Town & Country Planning Act 1990 (as amended)
Town & country Planning (Development Management Procedure) (England) Order 2015
Application for Planning Permission for Works or Extension to a Dwelling

Development Proposed front extension, front elevational alterations, rear dormer and internal alterations.

Location Holyrood Sylvan Way Bognor Regis

Proposed Block Plan 1:500

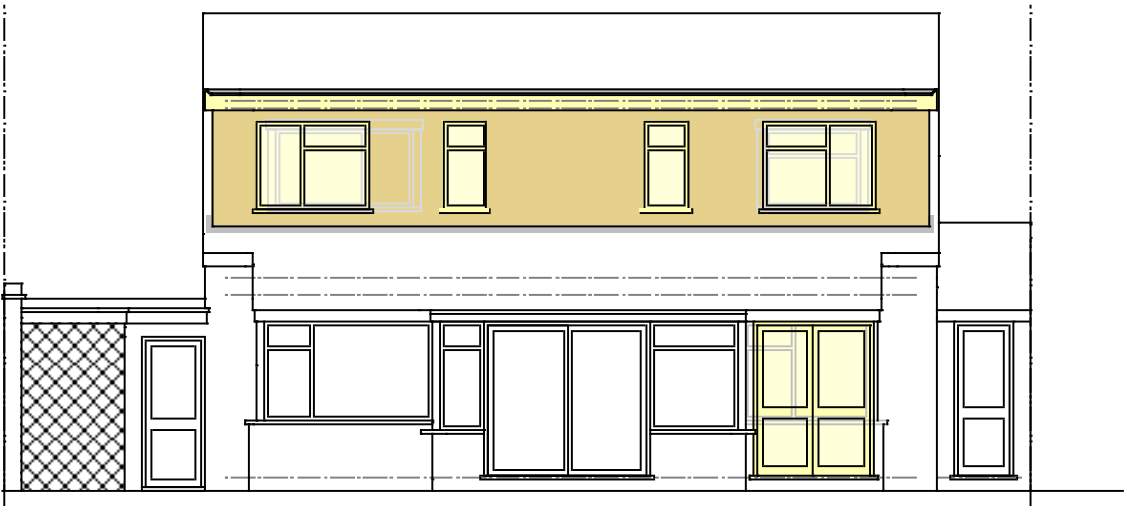
Block Plan

Please submit 1 electronic or 3 paper copies of a block/site plan which includes all dimensions from the proposed extension(s) to all site boundaries at a scale of 1:500 or 1:200. Further details of what must be included on the plan can be found in the National Validation Requirements.
